WEST SUSSEX COUNTY COUNCIL CONSULTATION

TO:	Arun District Council FAO: Maria Tomalova
FROM:	WSCC - Highways Authority
DATE:	24 May 2021
LOCATION:	7 Ambleside Close Felpham PO22 8NG
SUBJECT:	FP/86/21/PL Erection of 1 No. 3 bed dwelling (resubmission following FP/179/20/PL).
DATE OF SITE VISIT:	n/a
RECOMMENDATION:	Advice
S106 CONTRIBUTION TOTAL:	n/a

PROPOSED SITE LAYOUT & MASSING

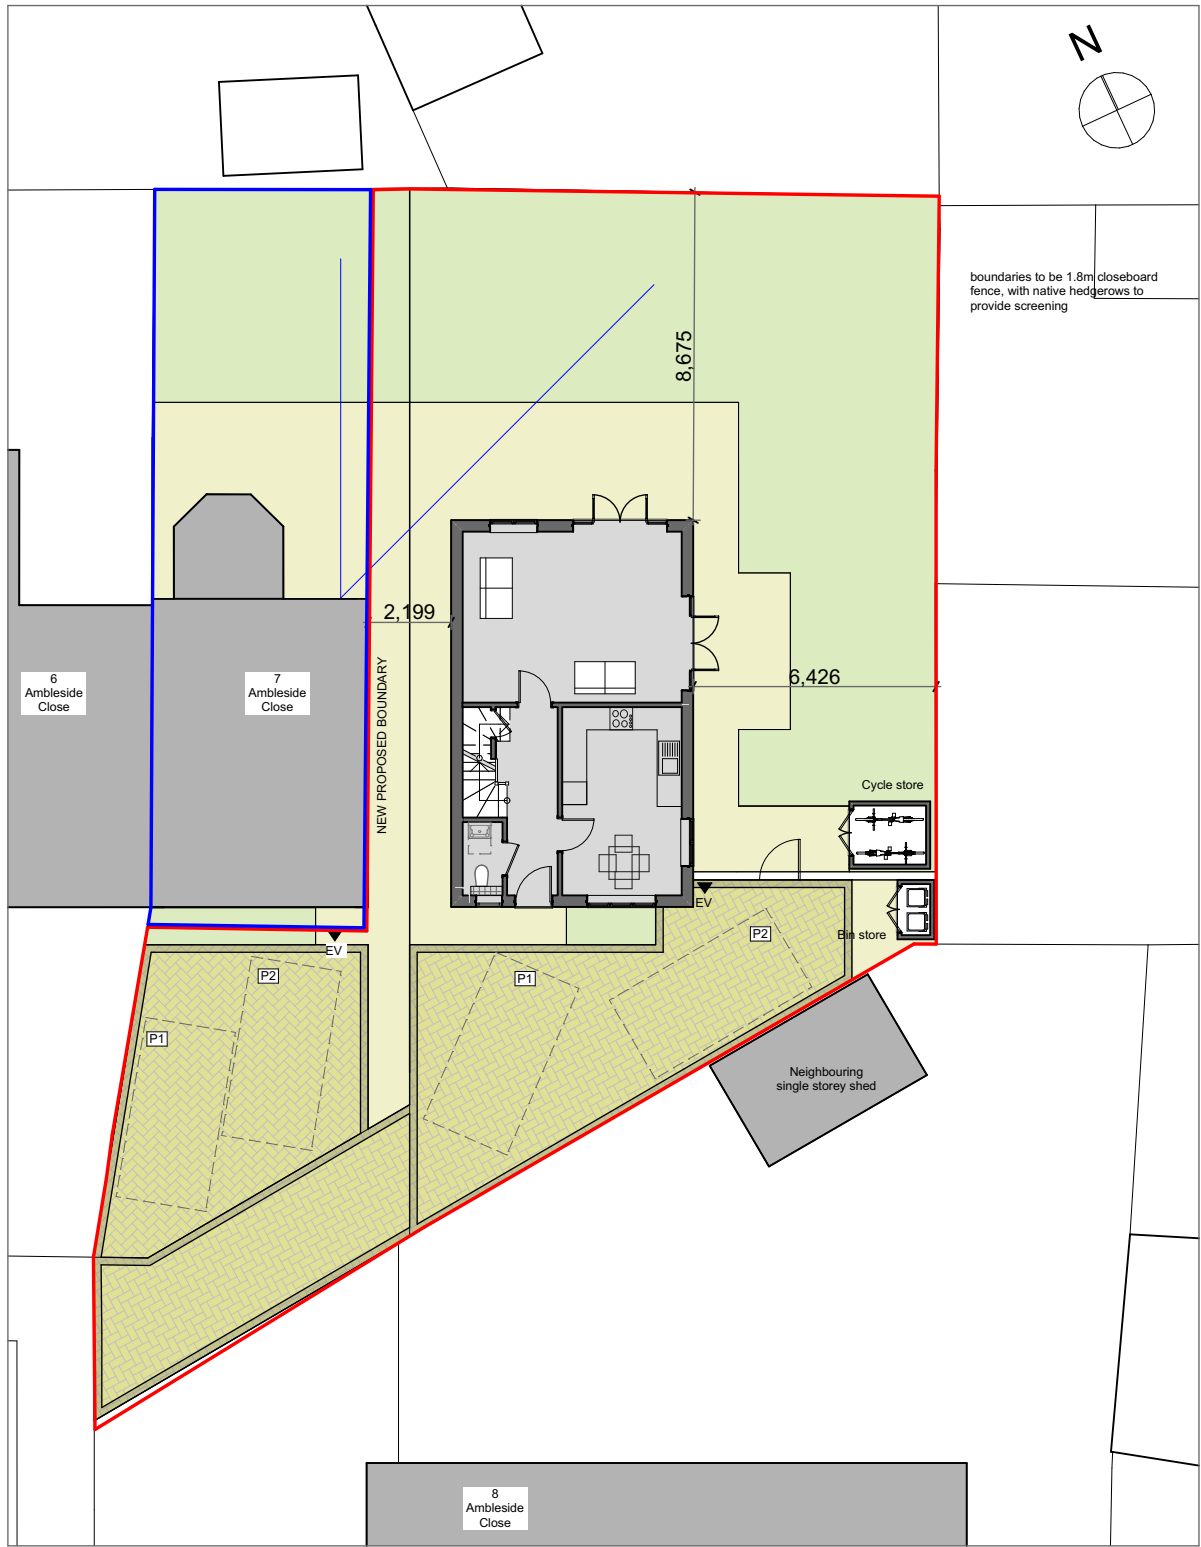
The proposal will utilise the existing access onto Ambleside Close, providing a shared driveway and two parking areas for both the existing and proposed dwellings. No visibility issues with the access arrangement are anticipated. The proposed driveway will be 2.8m in width - the Transport Statement confirms that no entrance gates will be provided to the proposed dwelling, which overcomes the LHA's concerns regarding the narrowing of the entrance-way to just 2.4m.

Swept path tracking has been provided demonstrating that vehicles can enter and exit each space in forward and reverse gears. As such no highways concerns over the proposed parking arrangements would be raised. The LHA would also not raise a highway concern to the lack of on-site turning space on site, given the nature of the no-through residential road and neighbouring properties operating similar arrangements.

The site is sustainably located within walking distance of local shops and amenities and primary and secondary schools. Secure and covered cycle storage is proposed within the rear garden of the proposed dwelling to encourage sustainable transport methods.

No part of the development shall be first occupied until the car parking has been constructed in accordance with the approved site plan. These spaces shall thereafter be retained at all times for their designated purpose.

No part of the development shall be first occupied until covered and secure cycle parking spaces have been provided in accordance with the approved site plan.
